# CITY OF ALBUQUERQUE

RE: **5501 Bell SE**  
**Grading Plan**  
**Engineer's Stamp Date 6/21/17 (File: L18D082)**

Based on the information provided in your submittal received 6/22/17, the Grading Plan cannot be approved for Building Permit until the following are addressed:

GRADING AND  
DRAINAGE PLAN

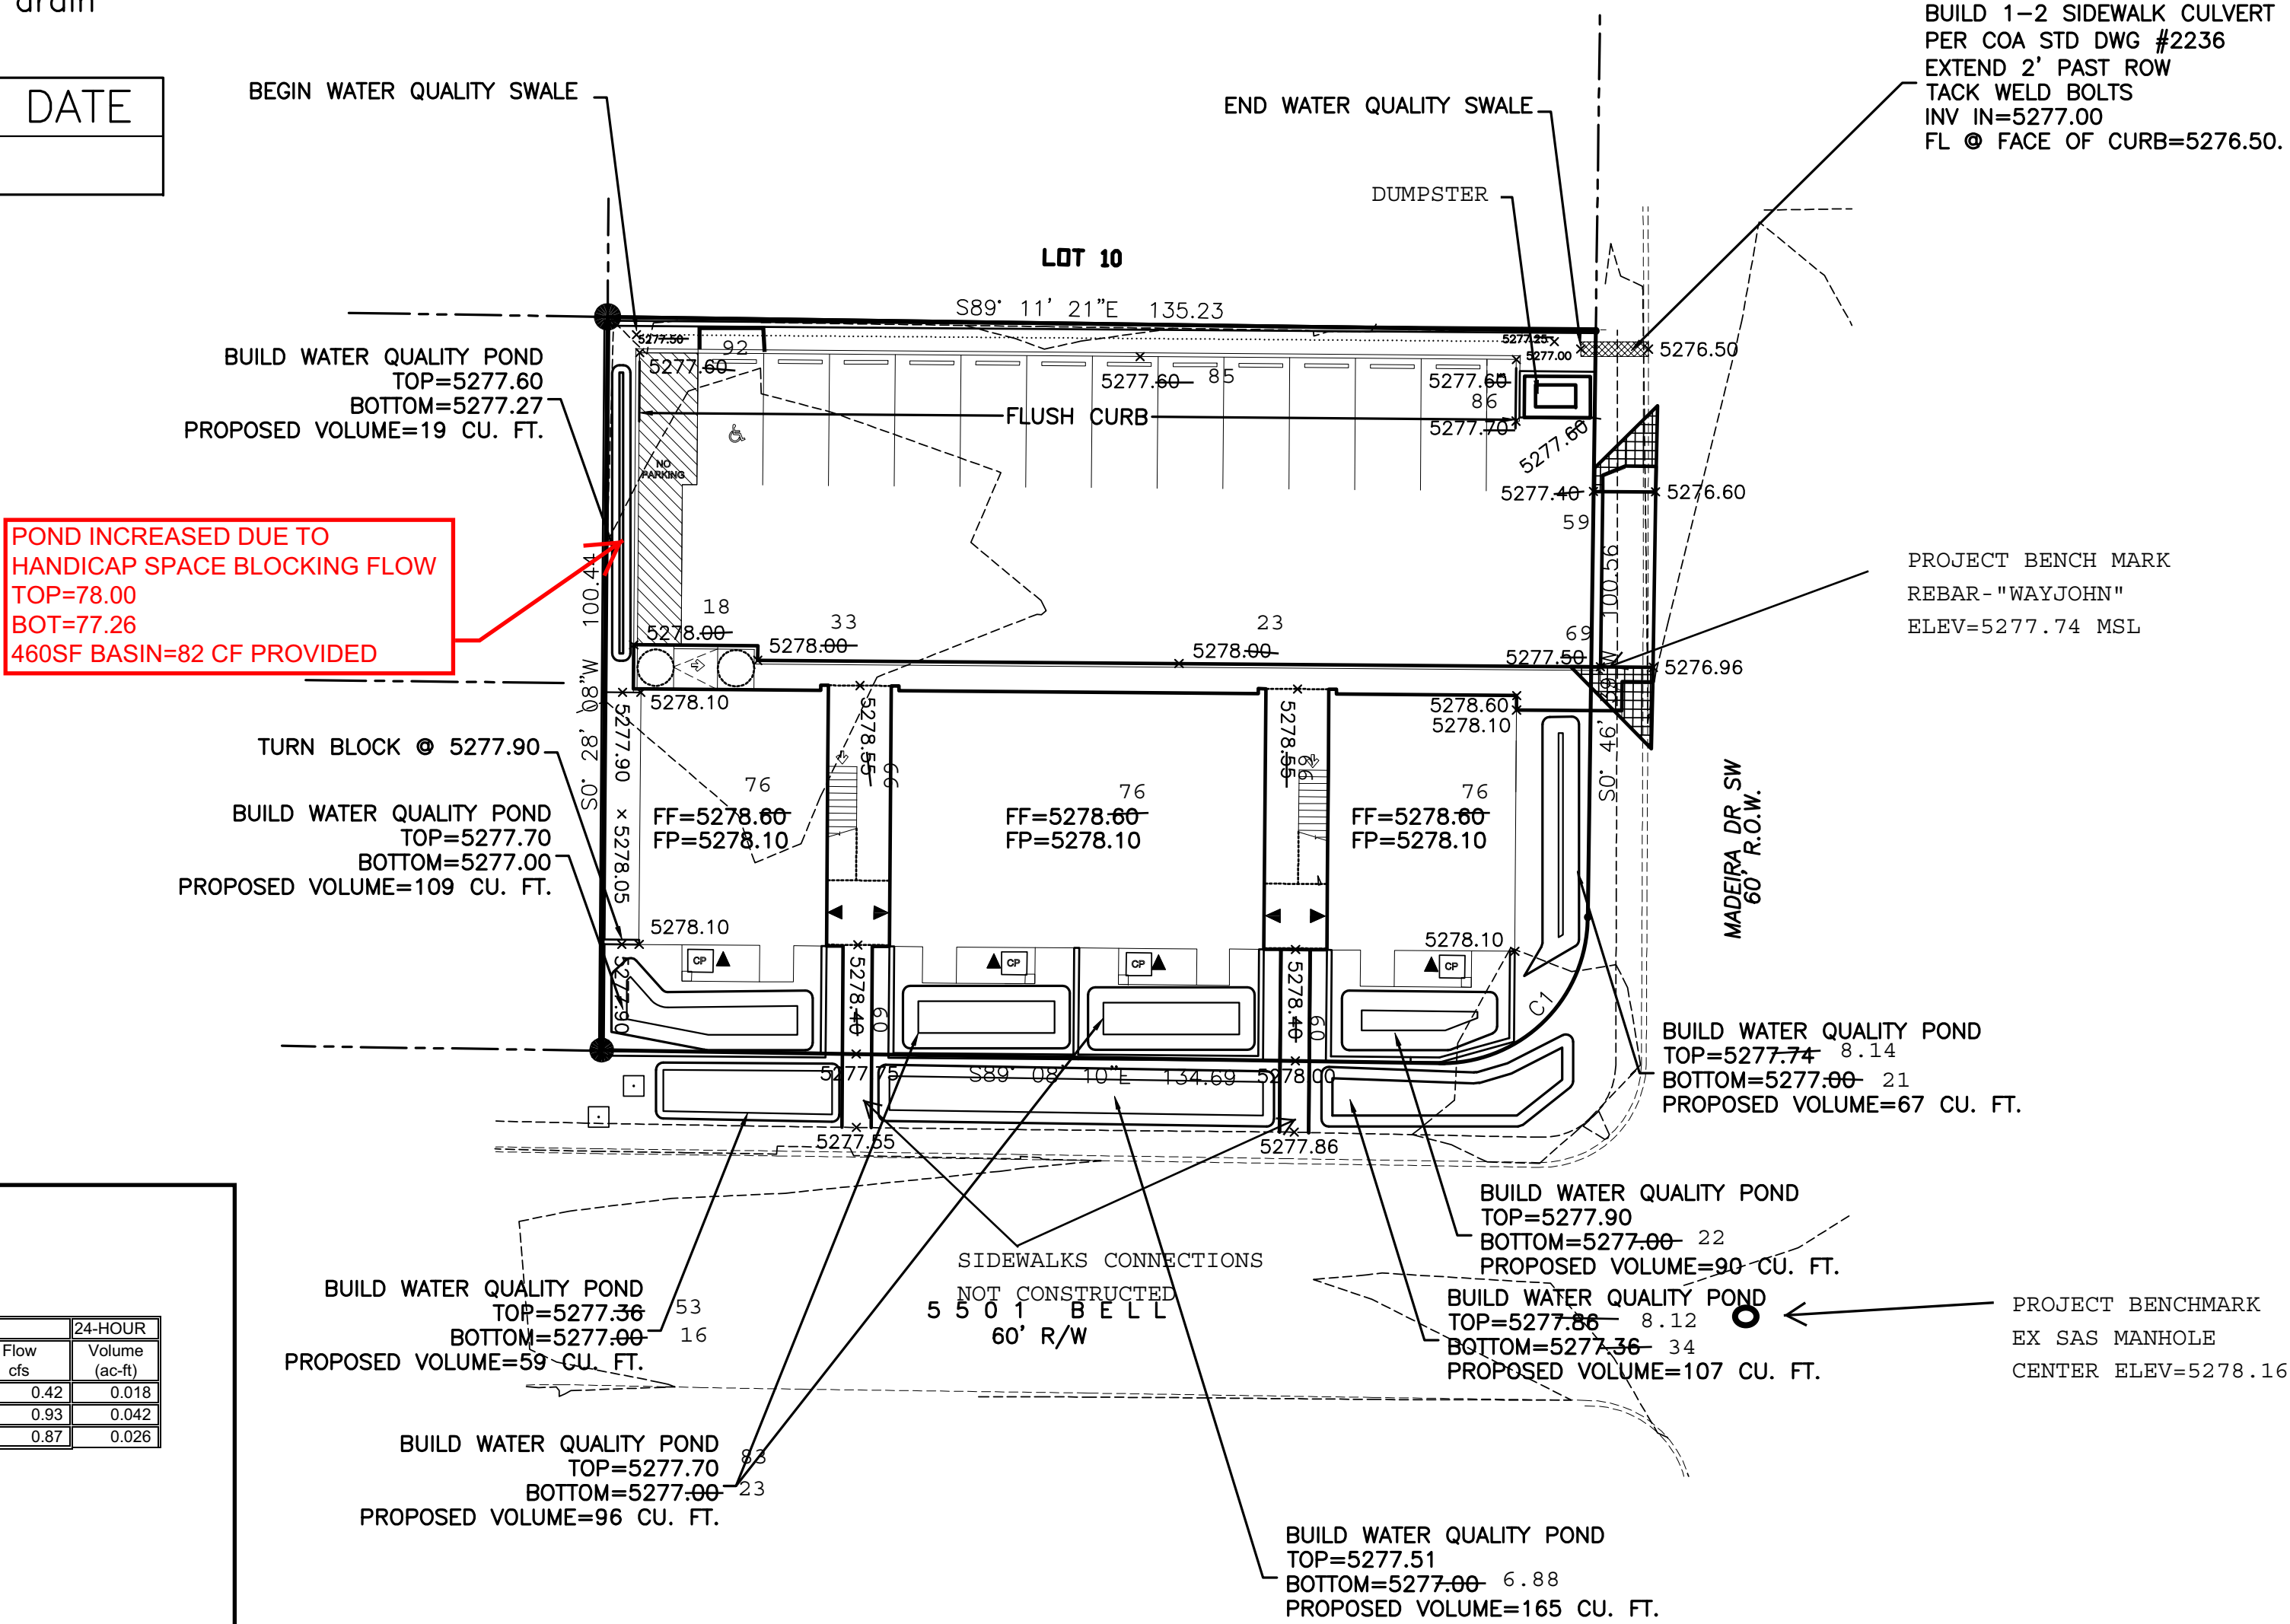
1. This site requires a Flood Plain Permit, submitted to Rudy Rael ([rrael@cabq.gov](mailto:rrael@cabq.gov)), for grading work in the flood plain.
2. Provide project benchmark information.
